Recommendation Report for Planning Permission for Works or Extension to a Dwelling

REF NO: BR/13/22/HH

LOCATION: 235 Hawthorn Road
Bognor Regis
PO21 2UW

PROPOSAL: Erection of two storey side extension and single storey rear orangery following the demolition of existing rear conservatory and side extension.

GROUND FLOOR PLAN PROPOSED 1:50

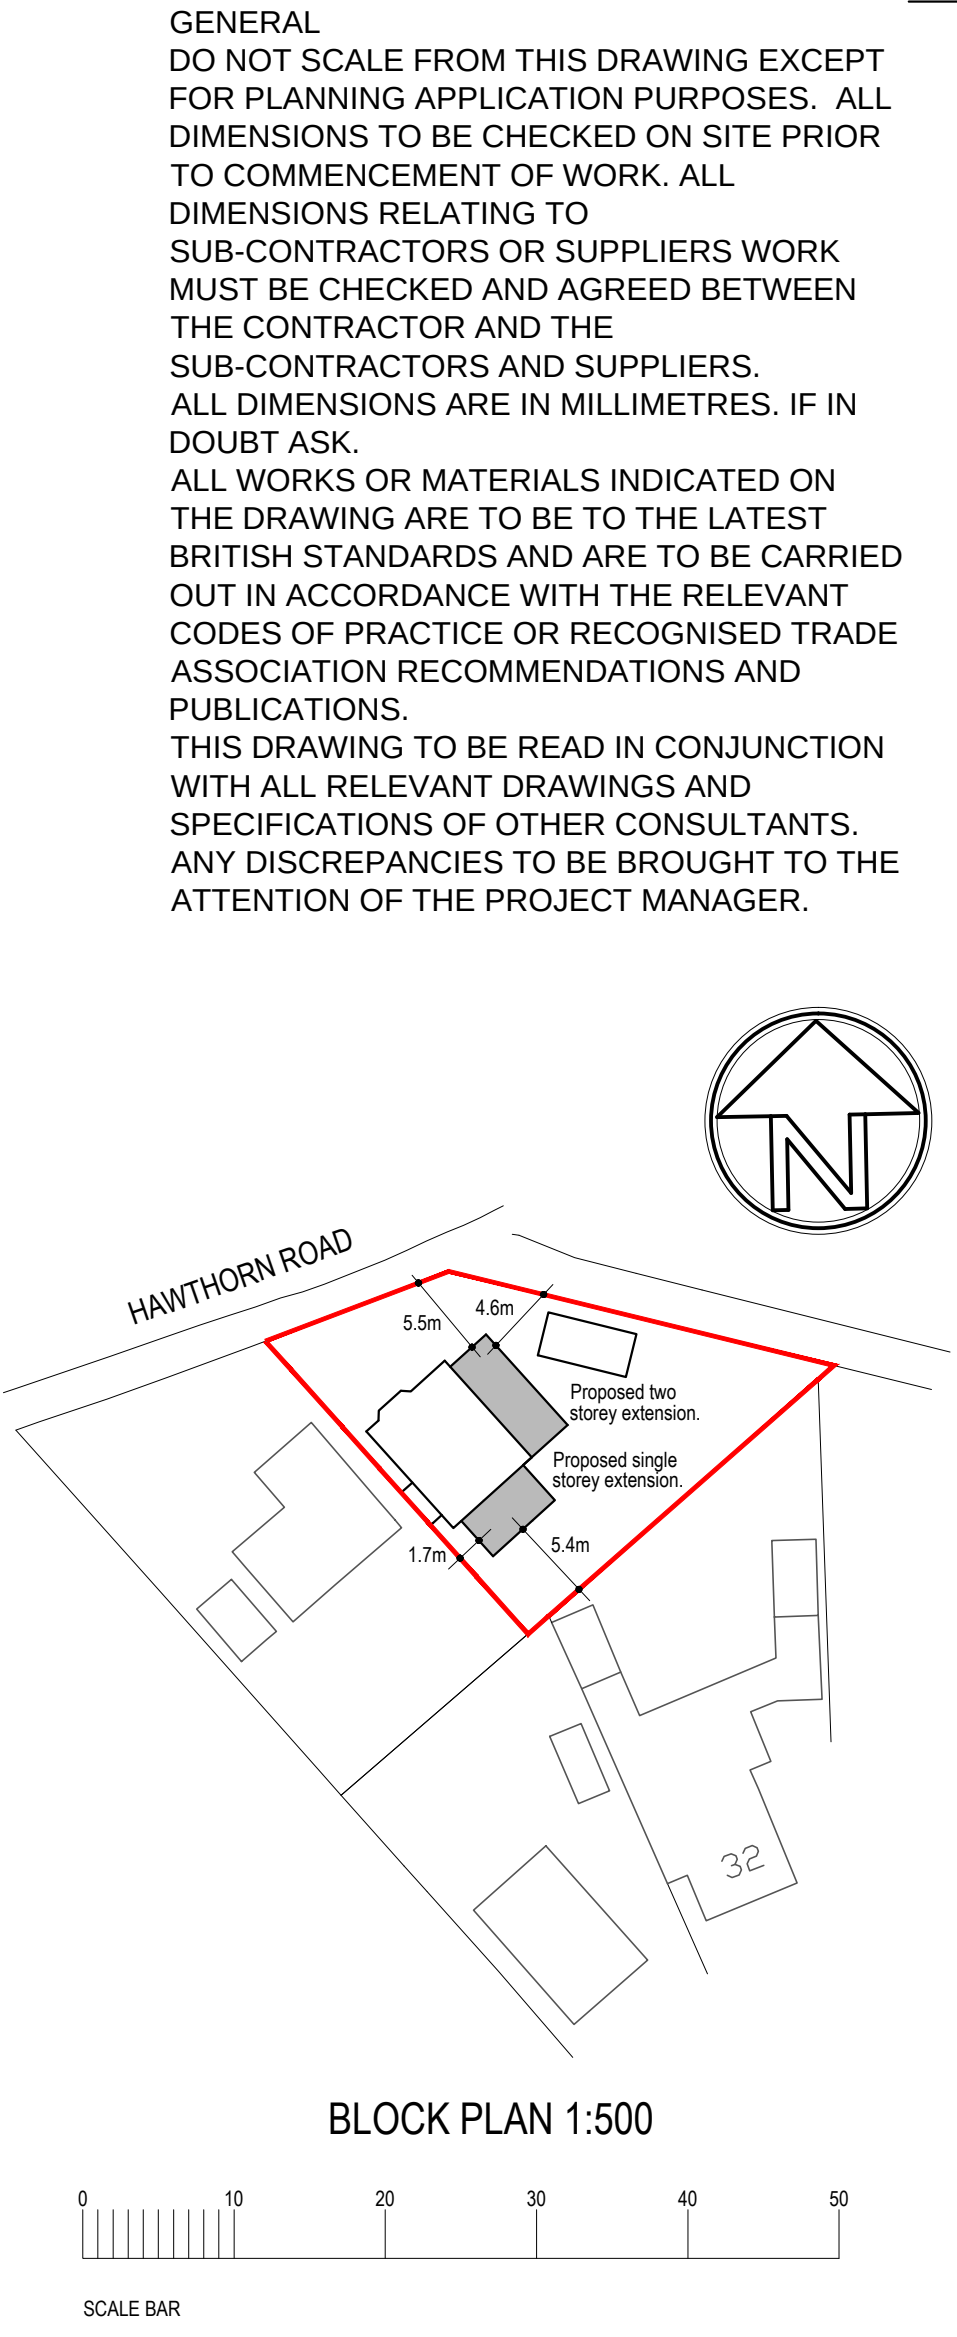
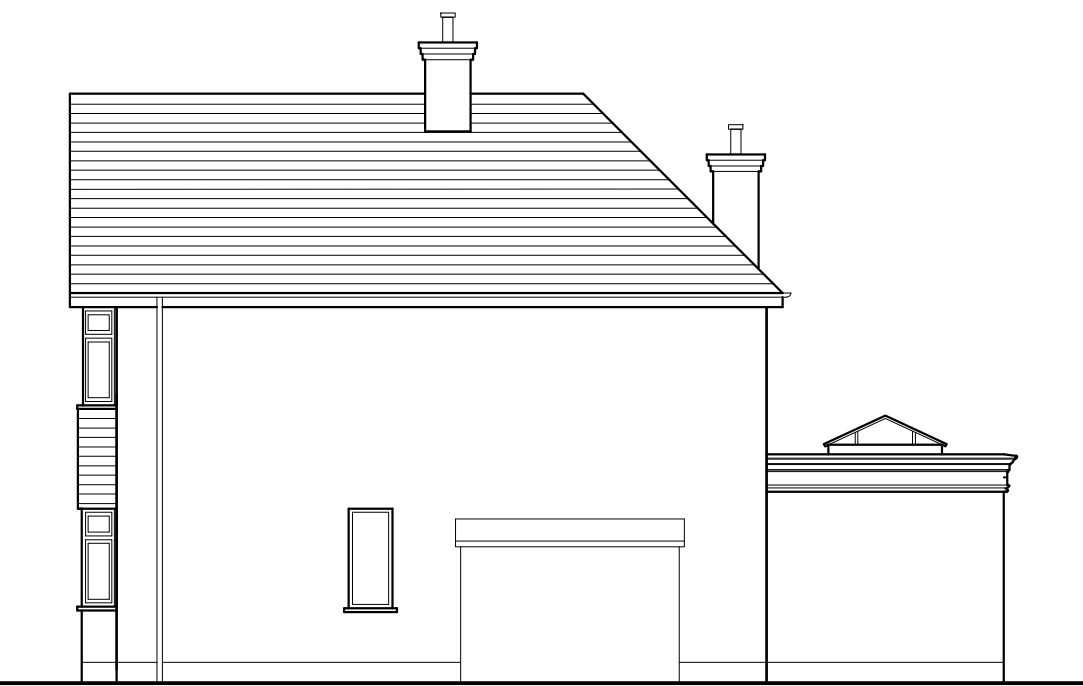
A two storey extension is proposed to the east side of the dwelling with a width of 3.15m. There is a single storey lean to which will be replaced. This runs along the full side elevation. The dwelling has a part cat slide roof with lower eaves to the front elevation. The proposal will continue the roof design and as such it appears well integrated with the host dwelling and appropriate in scale.

The front dormer has a pitched roof and is appropriate in scale to the roof slope. There is an existing gable roof to the front and the design is in keeping with that of the main dwelling.

The Arun Design Guide states ' In order to play a subservient role to the original building: the extension should be set down 1-1.5 metres for the ground floor and a minimum of 2 metres for the first floor ' The proposal does not comply with this, matching in height although appears well integrated. 'Extensions must not close important gaps in the street scene by leading to a terracing effect'. The proposal retains sufficient space to the boundary and with a public path running alongside it does not result in a terracing effect. Part M states: "Dormers should be a minor incident in the roof plane and made of sympathetic to the existing or original building materials'. ' Favours small scale dormer windows with pitched roofs over large, flat box-shaped designs'. The dormer complies with the guidance, featuring a pitched roof.

The two storey extension will have a width of 3.15m and run along the full side elevation, meeting with the rear building line and will match the ridge height of the dwelling. The extension retains a minimum of 4.6m to the side boundary and 8.6m to the rear. There is a public footpath which runs along the side boundary and with no neighbours to this side and acceptable separation to the rear, the two storey element will not give rise to adverse overbearing or overshadowing impacts.

To the ground floor is a conservatory which will be replaced with a single storey extension of the same footprint. This will have a depth of 3.1m and a flat roof height of 3m which increases to 3.5m with the addition of a roof lantern. This is set in 1.75m from the south western boundary and does not appear to interest a 45 degree angle when drawn from the closest windows to the boundary . As such it does not result in adverse overbearing or overshadowing upon this elevation.

The two storey proposal will result in an additional two first floor rear facing windows serving a bathroom and a bedroom. The windows, specifically the bedroom window will provide additional overlooking upon the property to the rear at No.32. The bathroom window is in the existing building so may constitute permitted development and not require planning permission.

There is 19.5m separation from the window to the rear elevation of No.32 and whilst slightly short of the guidance, it is not deemed significant in which a refusal is justified. There is an existing rear facing window and views would be similar to that which are achievable from the existing bedroom. Some views may be possible to No.30 however due to the separation and the angle, views would not be significant.
